From: Sian Eggington [REDACTED]
Sent: 05 December 2019 17:07
To: Sian Eggington [REDACTED]
Subject: FW: Further Information Required on Your Ref: PP-08311427 Our Ref: BN/120/19/HH
Attachments: We sent you safe versions of your files; 04 Proposed Block Plan Rev B.pdf

From: Matt Bridle [REDACTED]
Sent: 04 December 2019 17:07
To: Planning <Planning@arun.gov.uk>
Cc: Planning.Responses@arun.gov.uk
Subject: RE: Further Information Required on Your Ref: PP-08311427 Our Ref: BN/120/19/HH

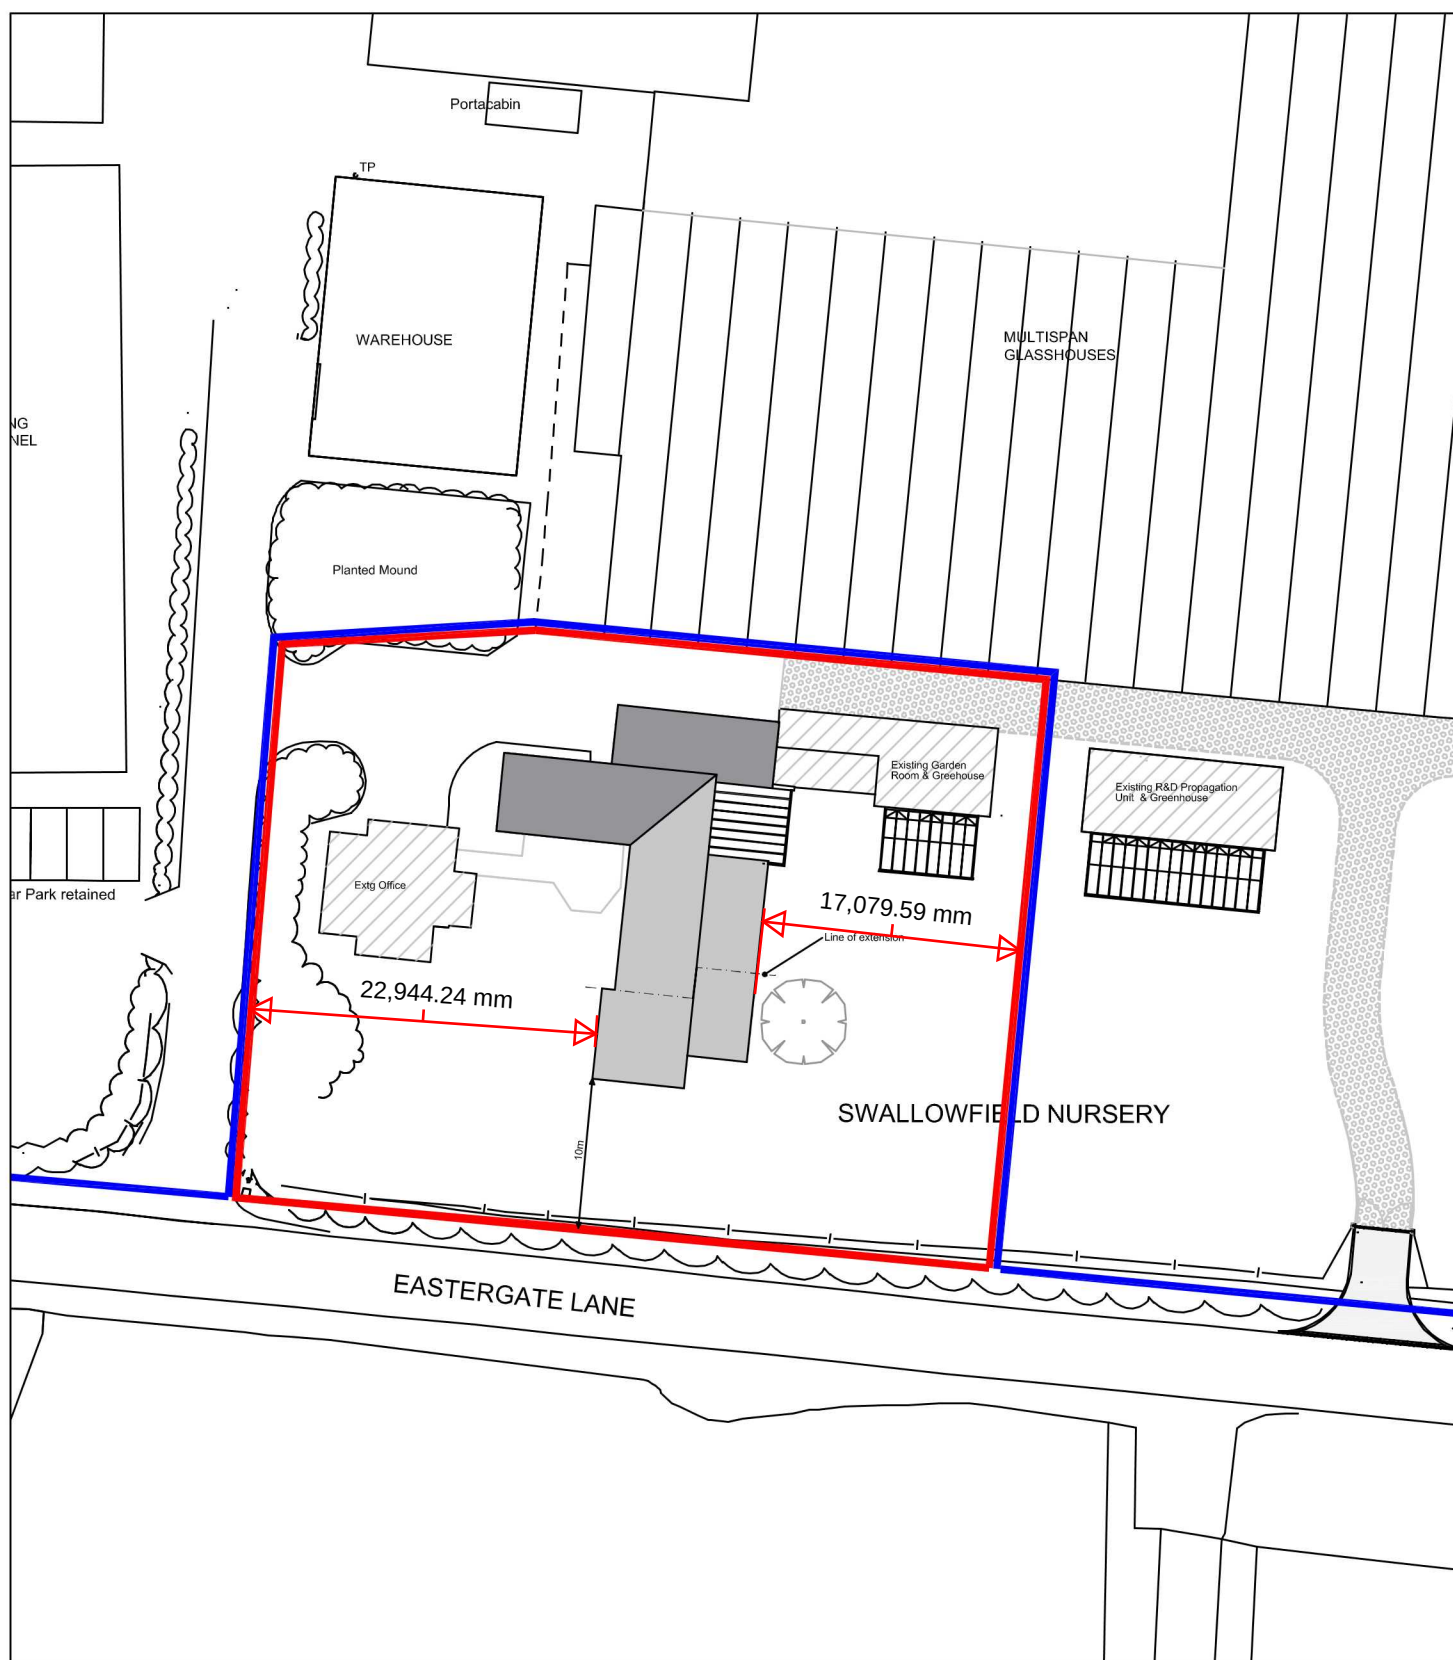
- i) Plan 4a Rev A – Revised and attached showing distance to the boundary
- ii) I confirm the intention is to connect the foul drainage to the public sewer that runs through of the site as noted on the application form.
